RIVERSIDE ENERGY PARK DCO

LB Bexley Deadline 5 Submissions

13 August 2019

LONDON BOROUGH OF
BEXLEY

Figure 7.9 Predicted Annual Mean NOx Concentration

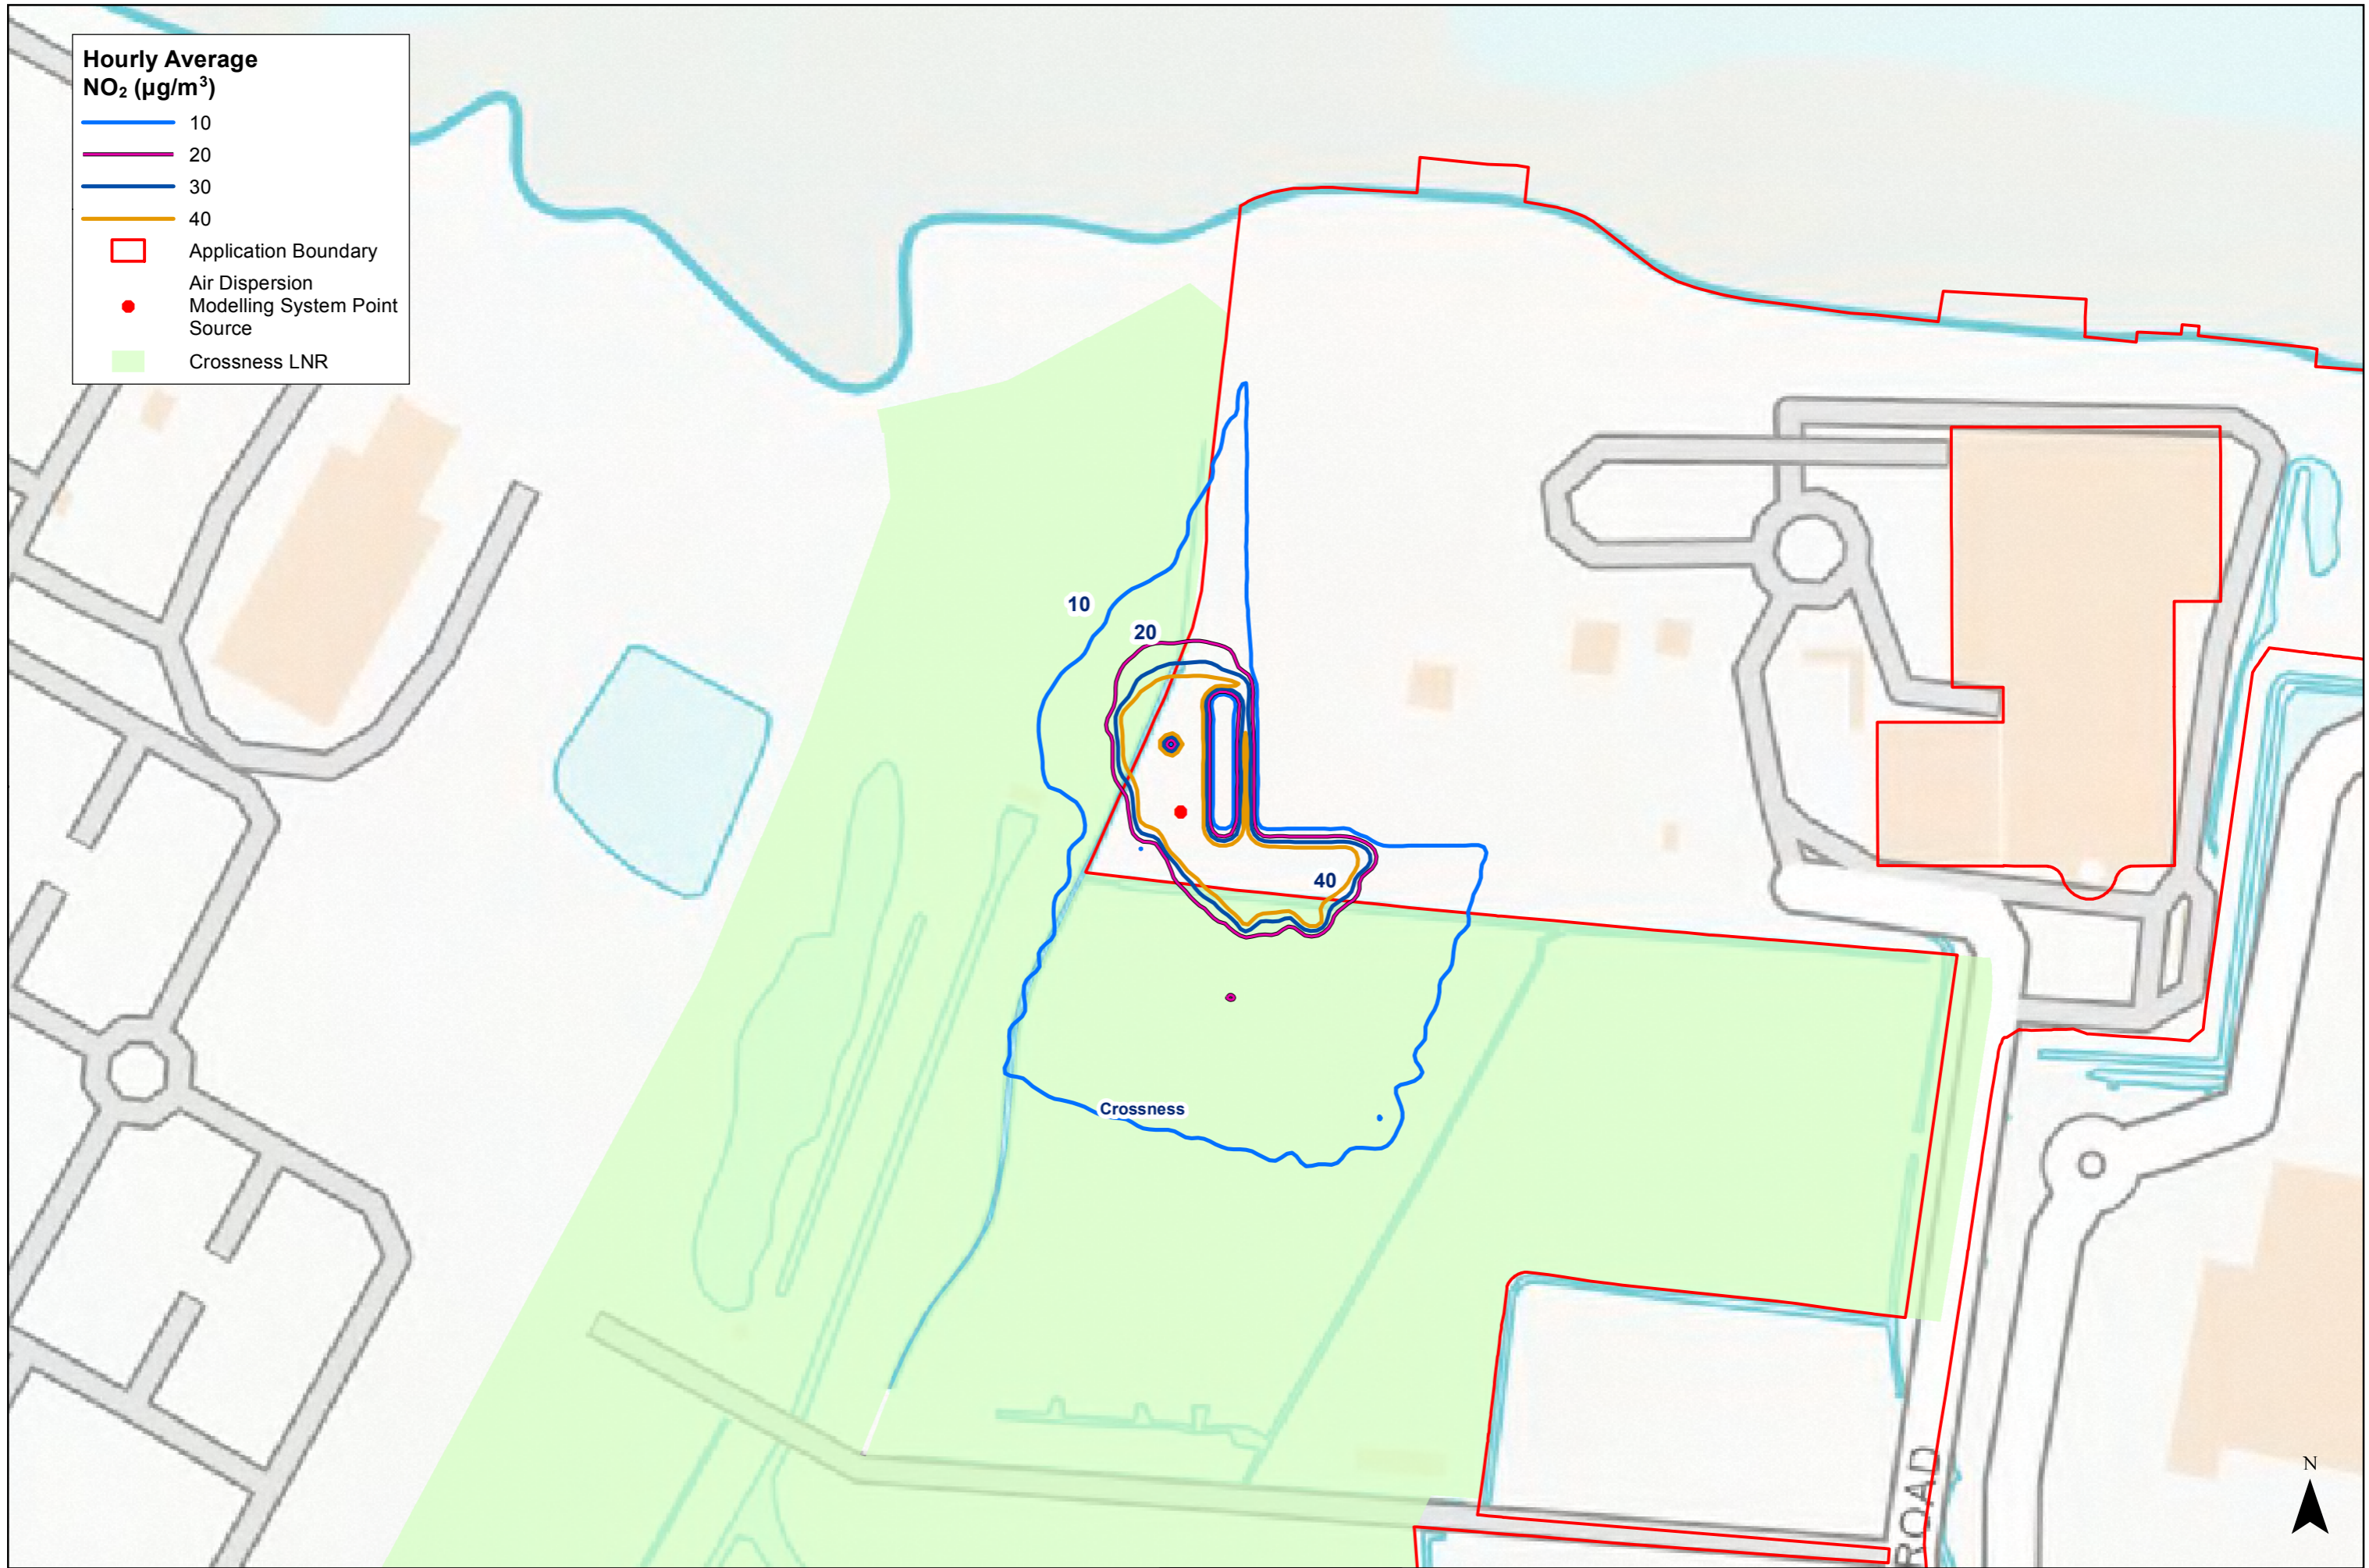
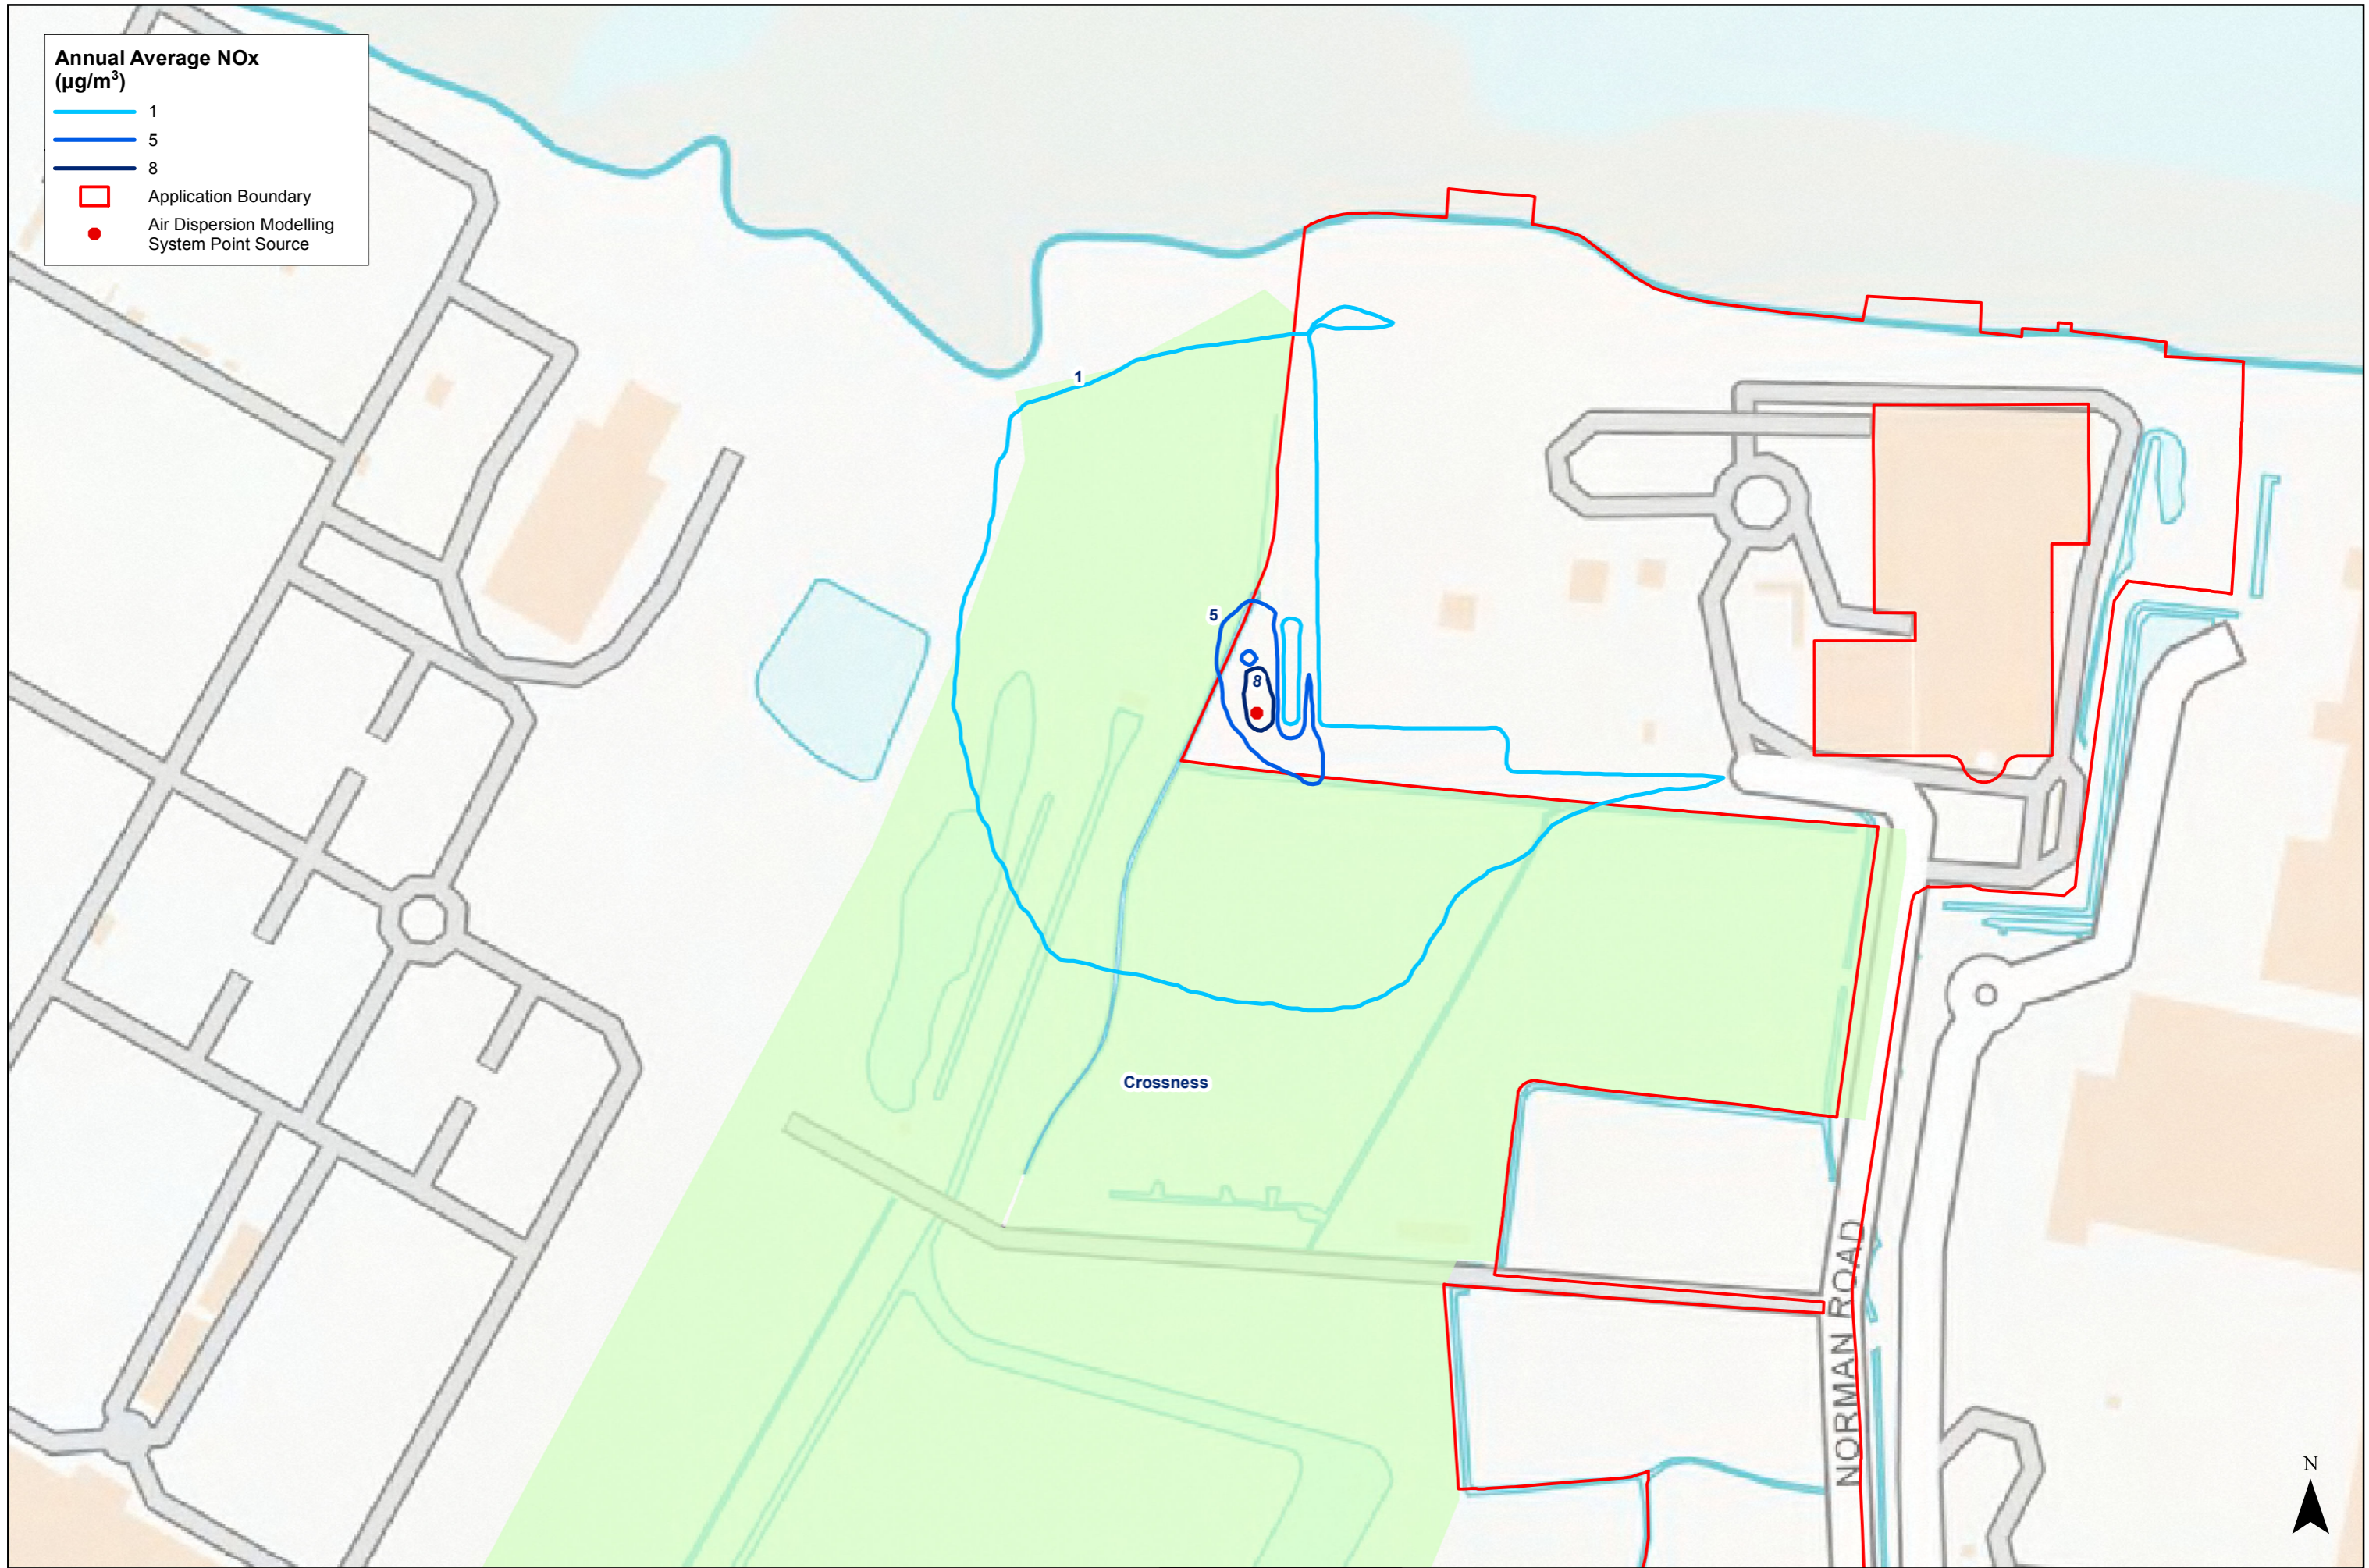
- 7.3 The legend for Figure 7.10 should be amended to be consistent with the contour labelling and main text.
